CITY OF ALBUQUERQUE

April 8, 2020

RE: Viva Paradise - Phase II
5516 Buglo NW
Revised Conceptual Grading and Drainage Plan
Engineer's Stamp Date: 04/06/20
Hydrology File: B11D010A

City Project No. **PR-2019-2333** Zone Map No. **B-11-Z** Sheet **2** Of **4**

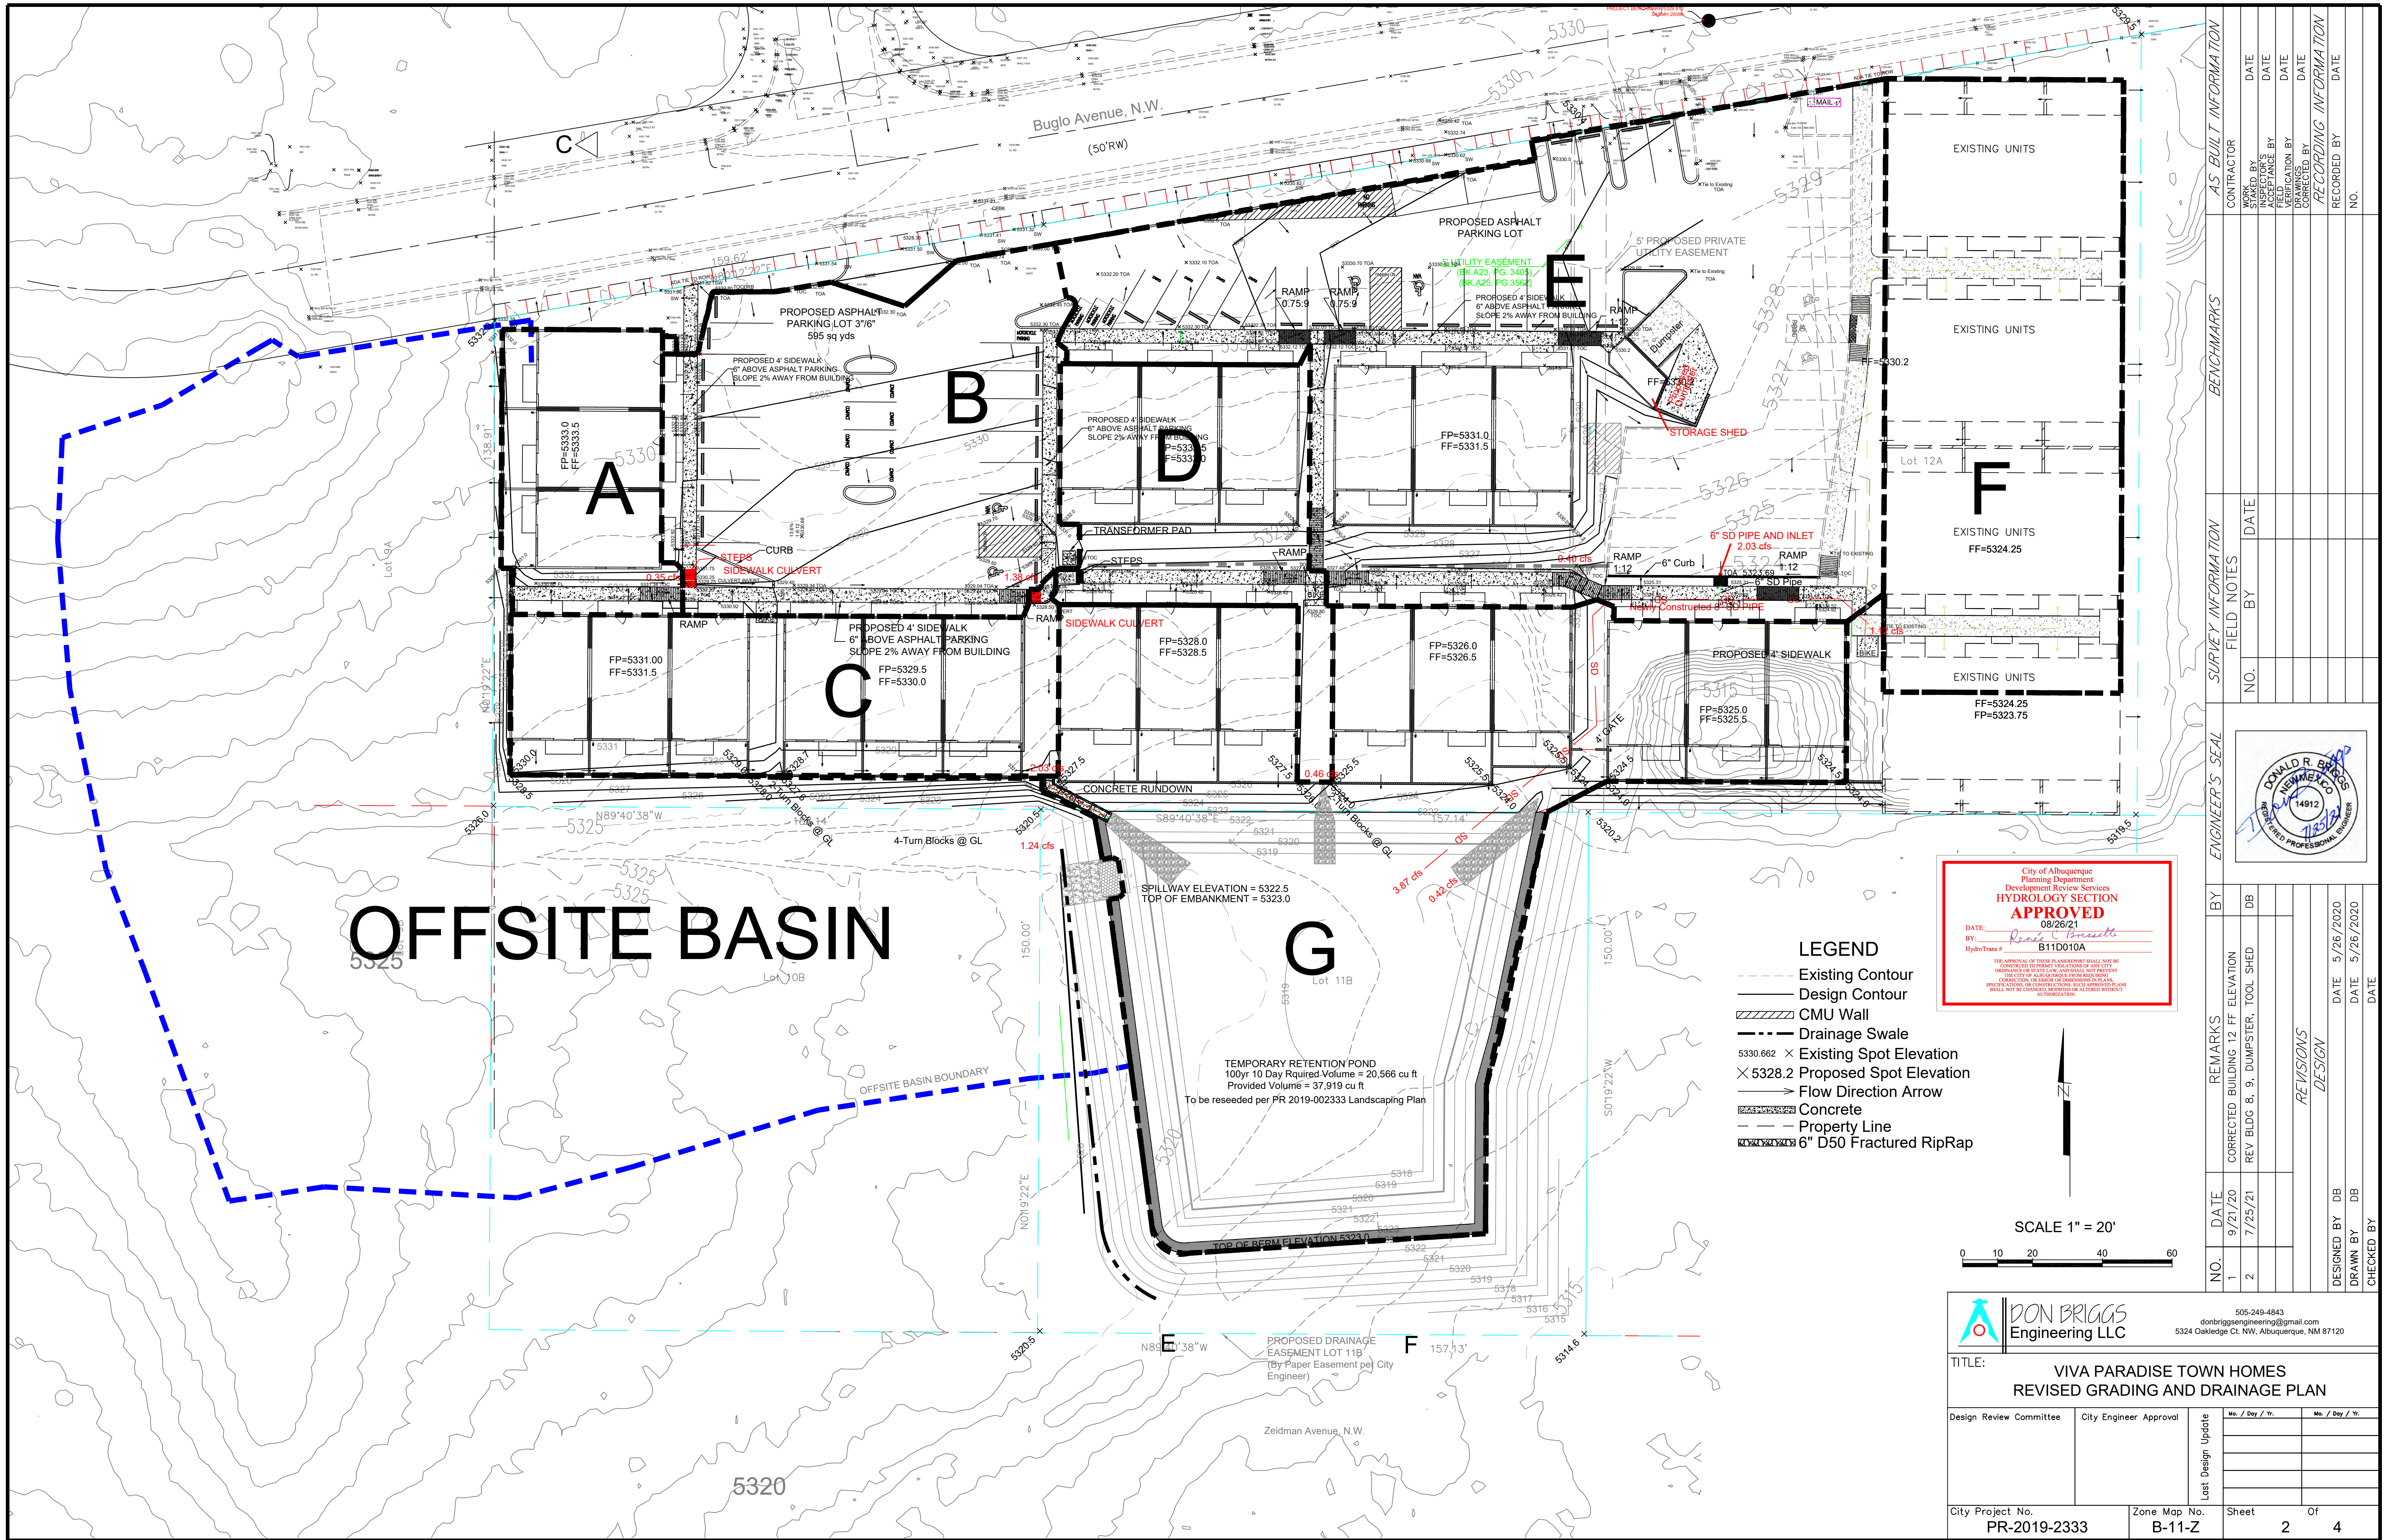
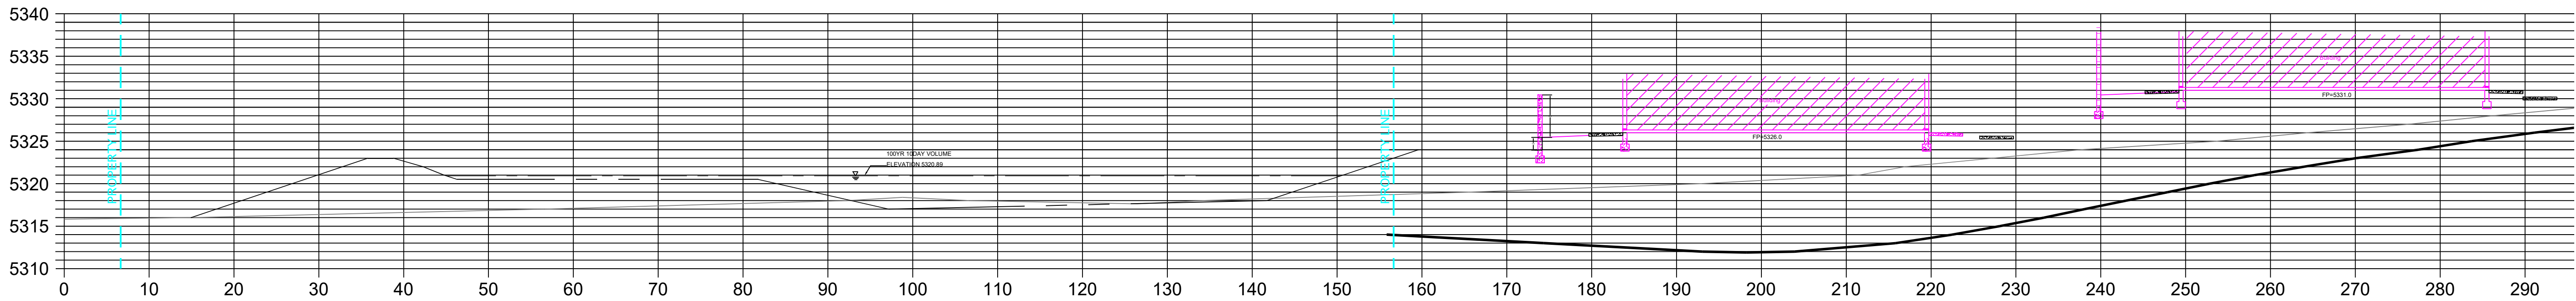
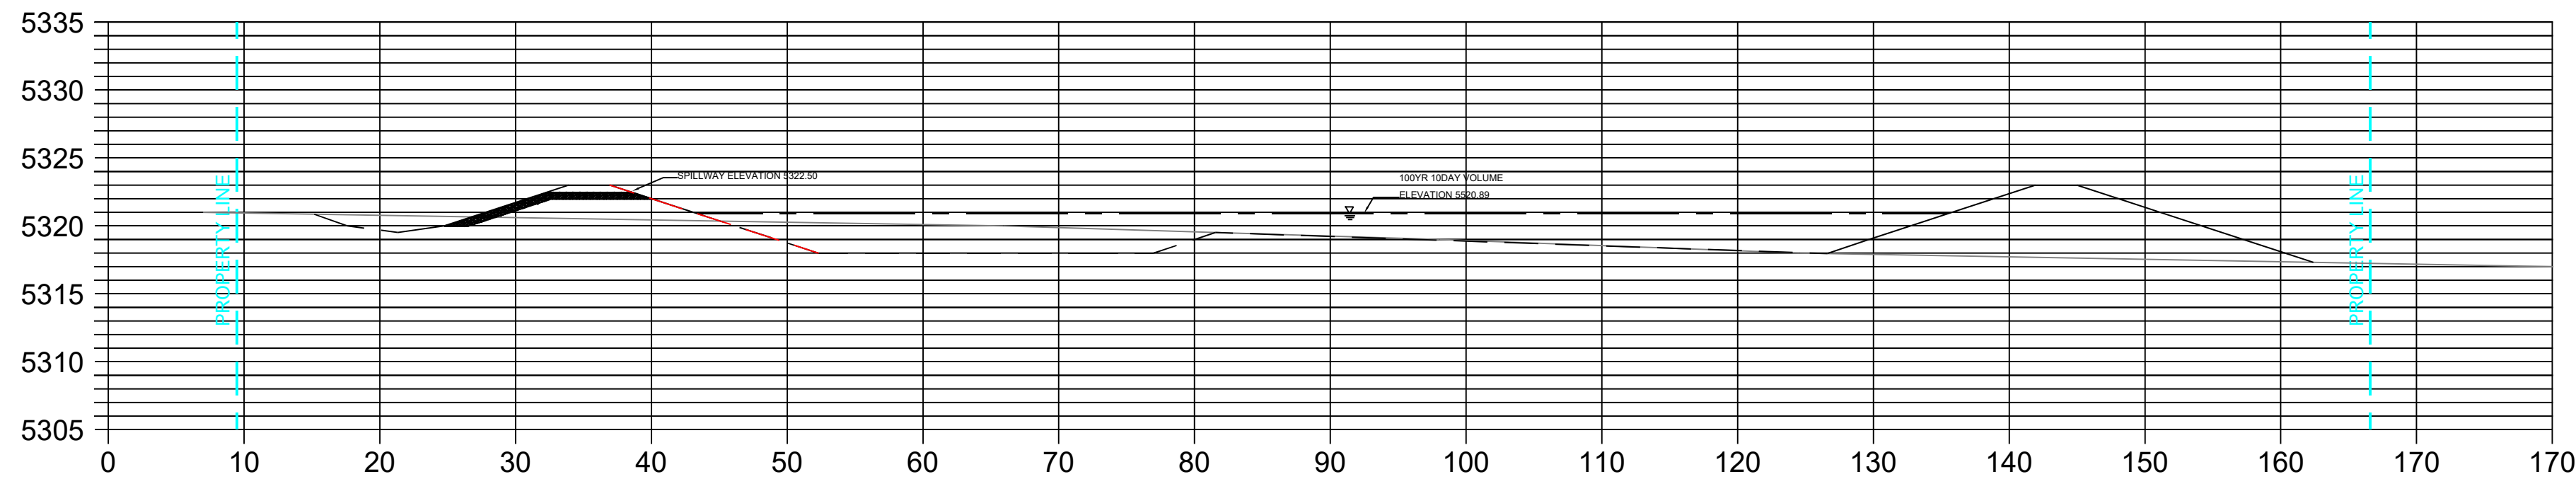
3. Drainage Calculations. Please provide the 100 year 10 day calculations for the retention pond sizing.
4. Please provide a cross section for the retention pond showing the 100 year 10 day volume water surface elevation.

SPILLWAY DESIGN DETAIL

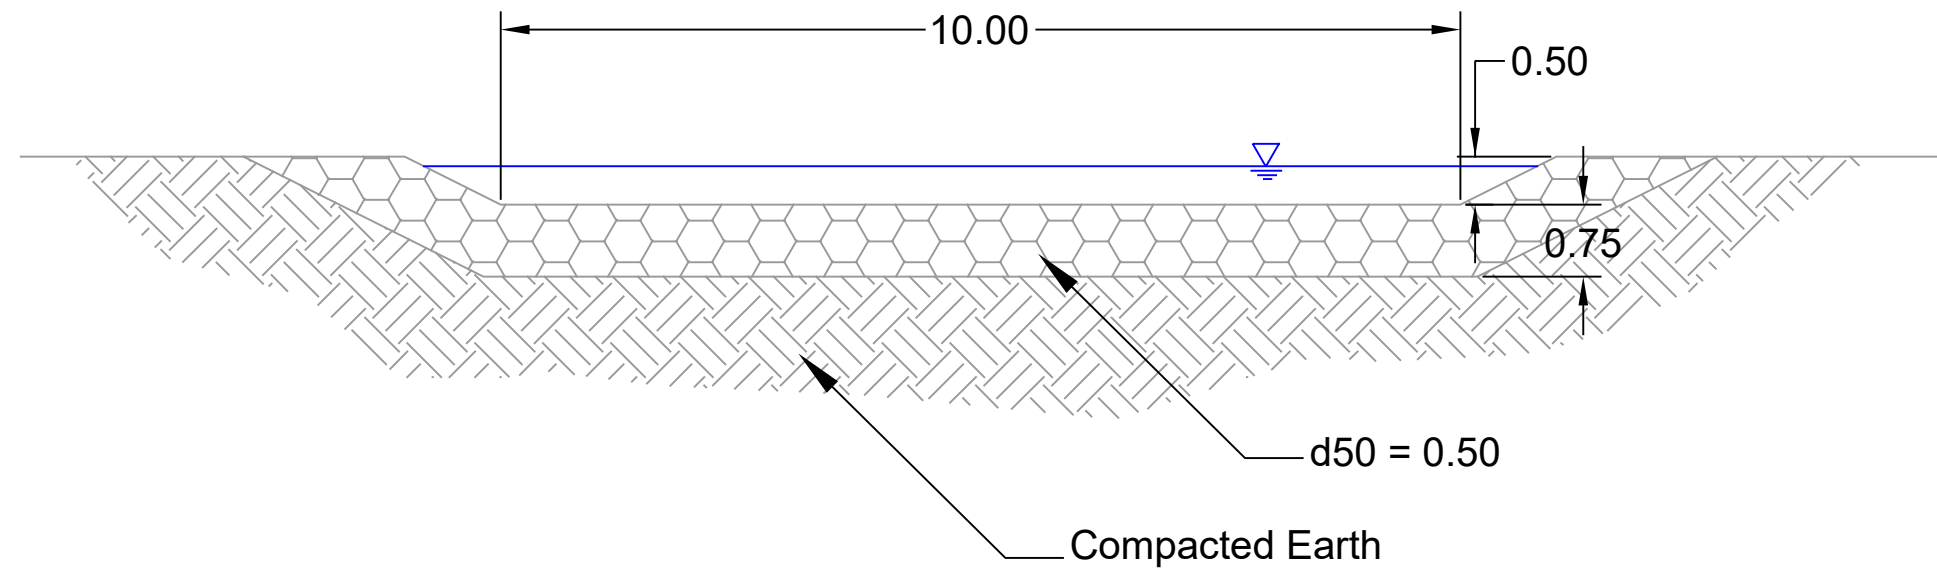
5. The emergency spillway should be located on the downward side of the retention pond. Please relocate it. If the shown spillway is actually for the off-site rundown, then re-adjust to make it just a rundown.
